Submission No.			194	
Organisation Name or Name of Submitter			Ambassador_Millenium Theatre Company (MTC)	
Item No.	Section Ref.	Page No.	Observation Statement	TII Response
MTC Cover letter - Re: Application by the National Roads Authority (operating as TII) for the Railway (Metrolink Estuary to Charlemont via Dublin Airport) Order [2022] Case Number. ABP-302010				
1	1. Introduction 1.7	4	There has been little substantive engagement by TII or discussion on mitigation measures prior to the submission of its application, and consequently MTC has had little time to consider the possible implications of the proposed development and to agree such mitigation measures in advance.	All mitigation measures have been carefully identified and assessed. Efforts were made to contact the landowner on more than one occasion prior to submission of the RO. TII continues to engage with landowners relative to their submissions

Project No.	20204	Project Name	Charlemont Station
Client	JACOBS	Project Manager	IDOM
Scale	1:10,000	Scale	DO NOT SCALE
Client No.	2710500	Client Name	METROLINK
Drawing No.	ML1-JA-EIA-ROUT_XX-DR-Y40027	Revision	P01

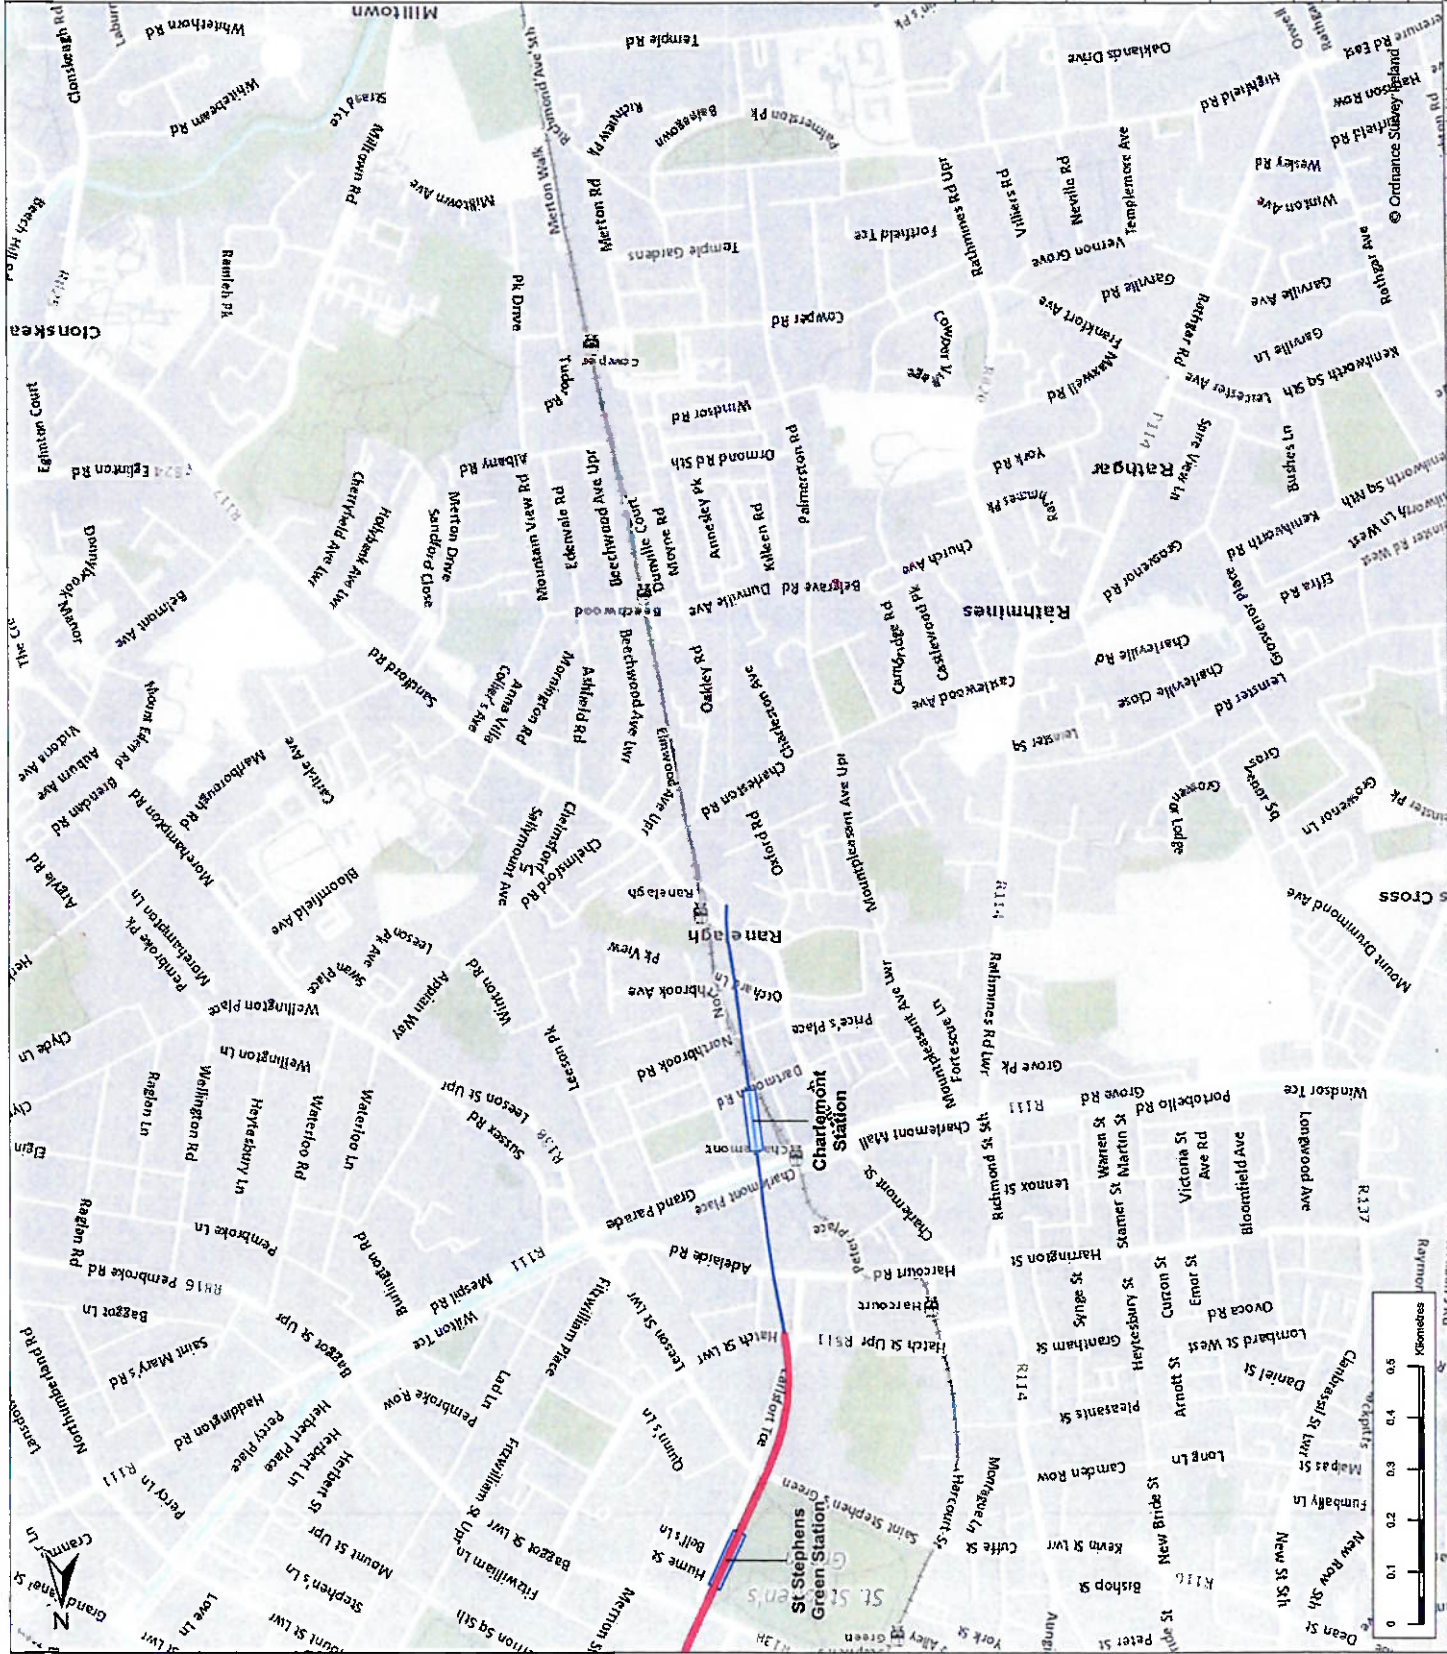
14	4.1 Impacts of Proposed Development on Ambassador Theatre - Noise & Vibration (f)	8	The applicant should be requested to incorporate and extend the "Floating Slab Track" for the entire Ambassador Theatre and well beyond as mitigation and to protect the building and to mitigate the impact on services at the Ambassador.	According to Chapter 14 Ground-borne Noise and Vibration, Table 14.47, Floating Slab Track will be used between Chainage 16+400 to Chainage 16+600. As the Ambassador Theatre building is located at Chainage 16+440 we consider that this length and positioning of the Floating Slab Track is adequate.

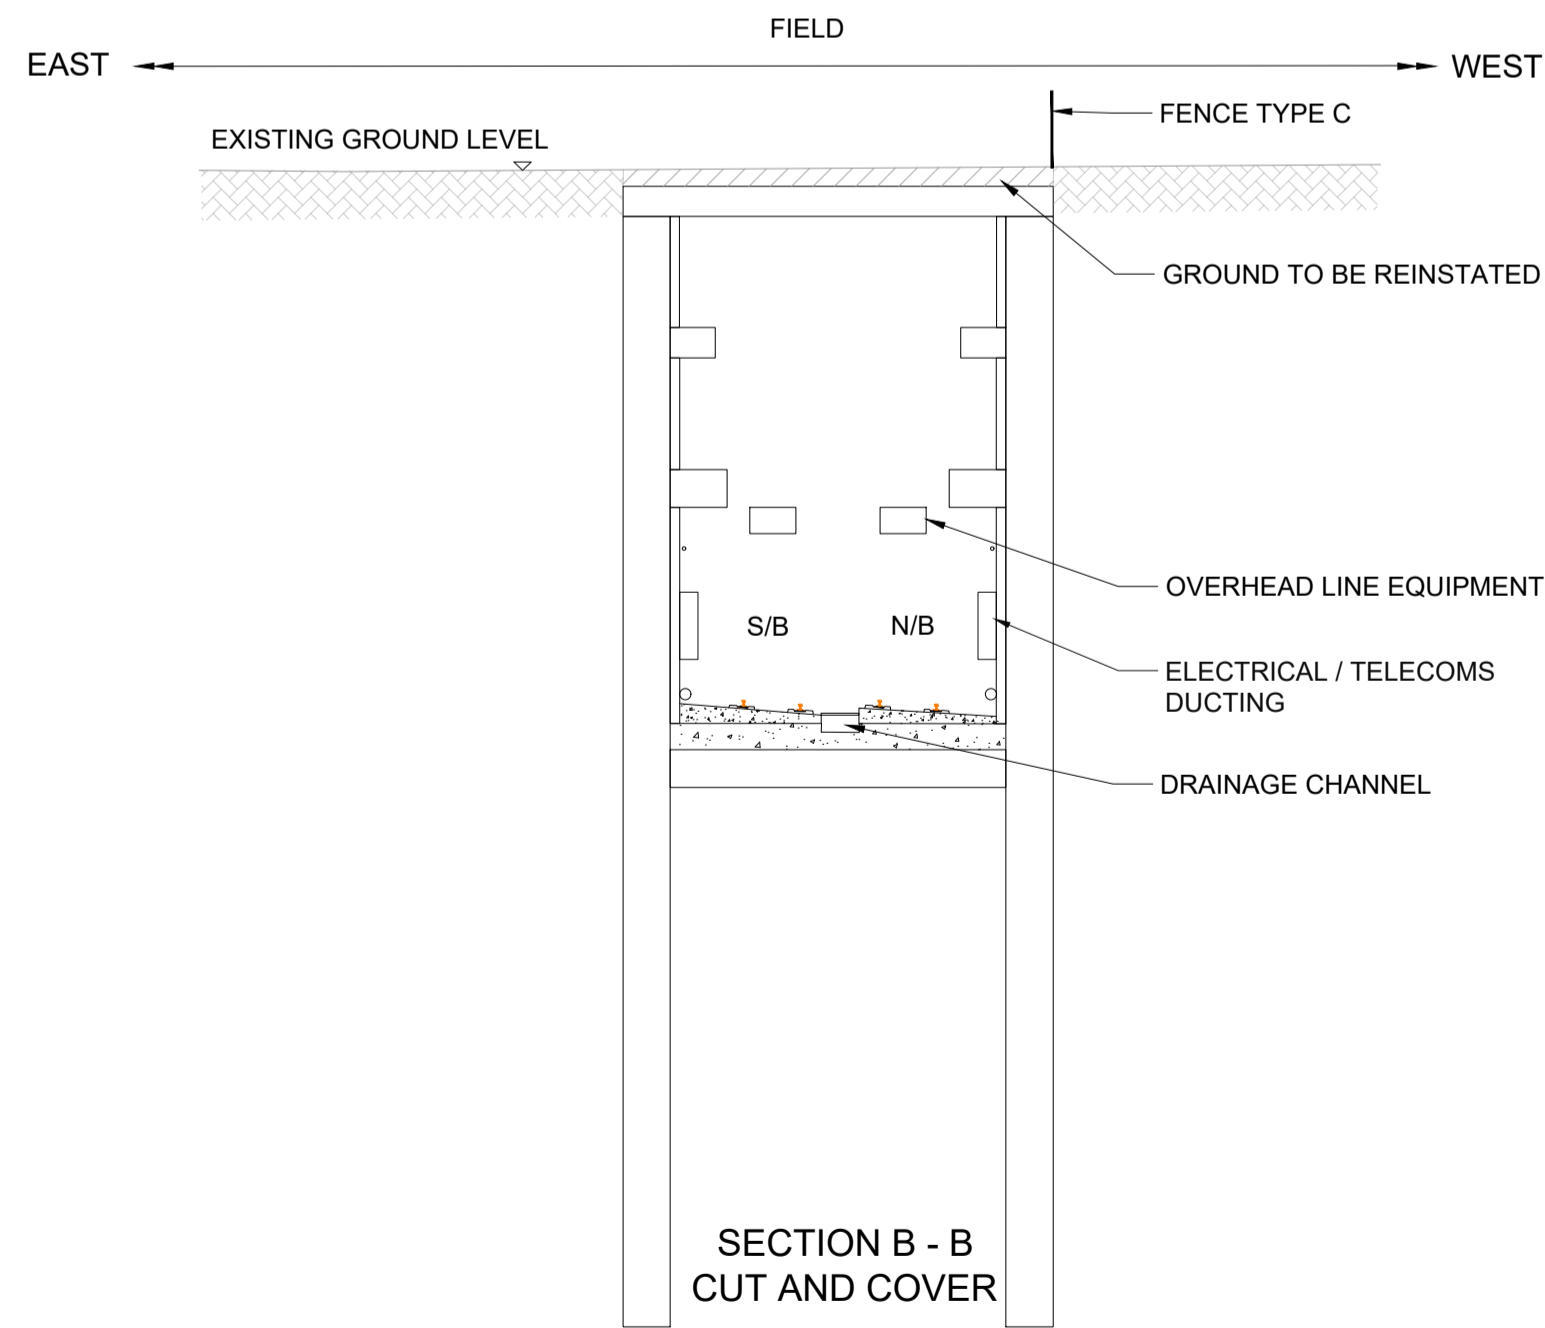
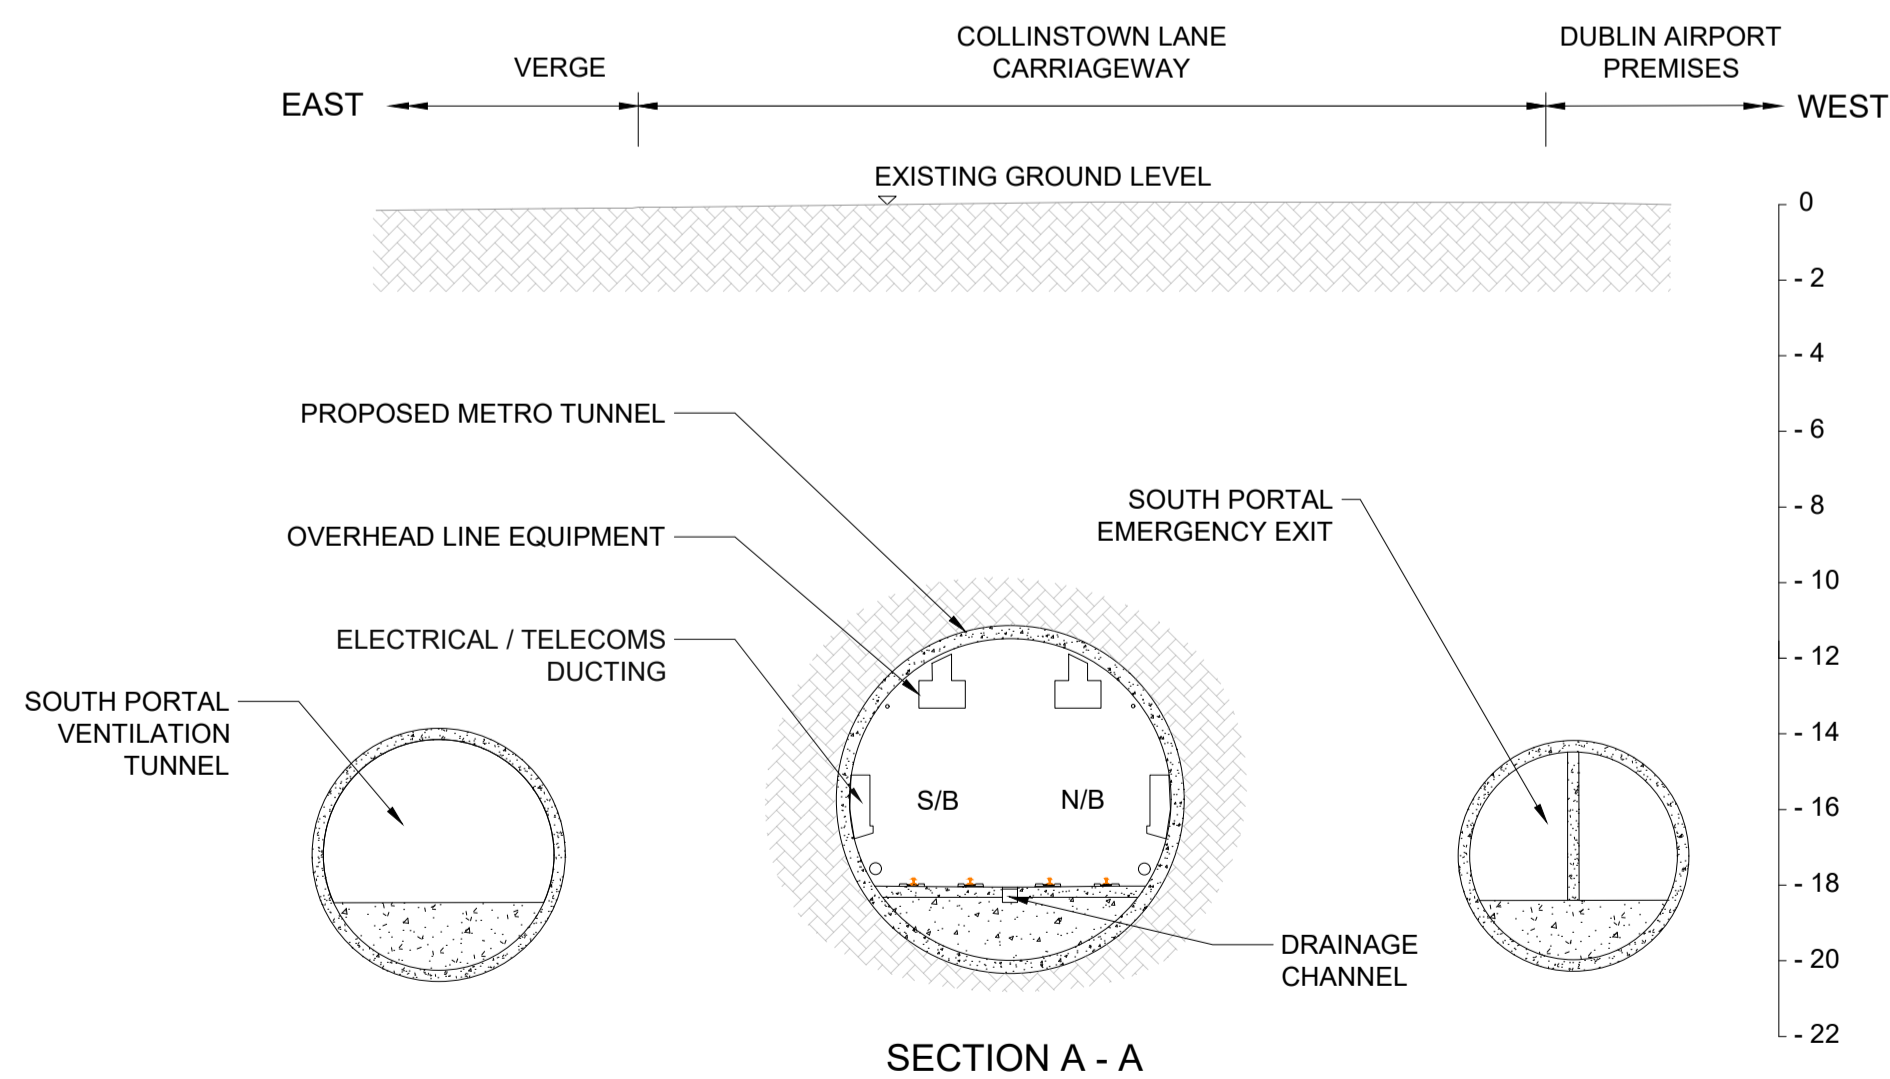
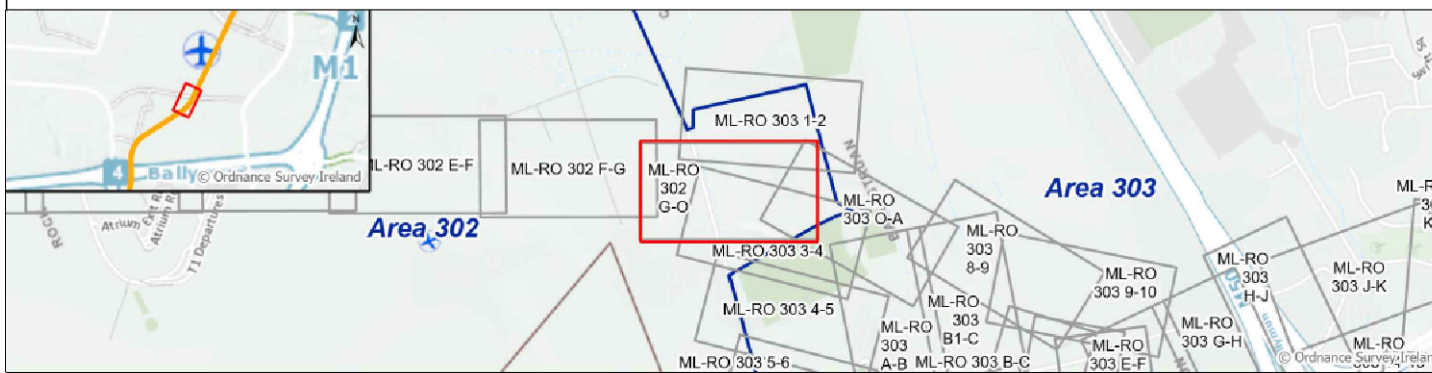
4	2. Proposed Development by TII 2.3	5	In addition to the construction impacts the potential long term zone of influence of the tunnels extends over the entirety of the Ambassador Theatre as set out on the drawing below.	The assessment noted above has taken all predicted movement in to account. Please note that once operational no further settlement impacts are anticipated.
5	2. Proposed Development by TII 2.4	6	The application, if granted, will also include powers for TII to acquire compulsorily land or rights in, under or over land or any substratum of land specified in the order: we understand that this will include substratum lands at the Ambassador although the MTC has not been advised of the extent of the lands this will impact.	TII wrote to the Millennium Theatre Company (letter reference CAP_ML_1175_48 dated 20th September 2022) and included all details with regard to the extent of subsurface acquisition proposed. Please refer to drgs ML-P 305 E-F and ML-5E-U16 included in this property pack.
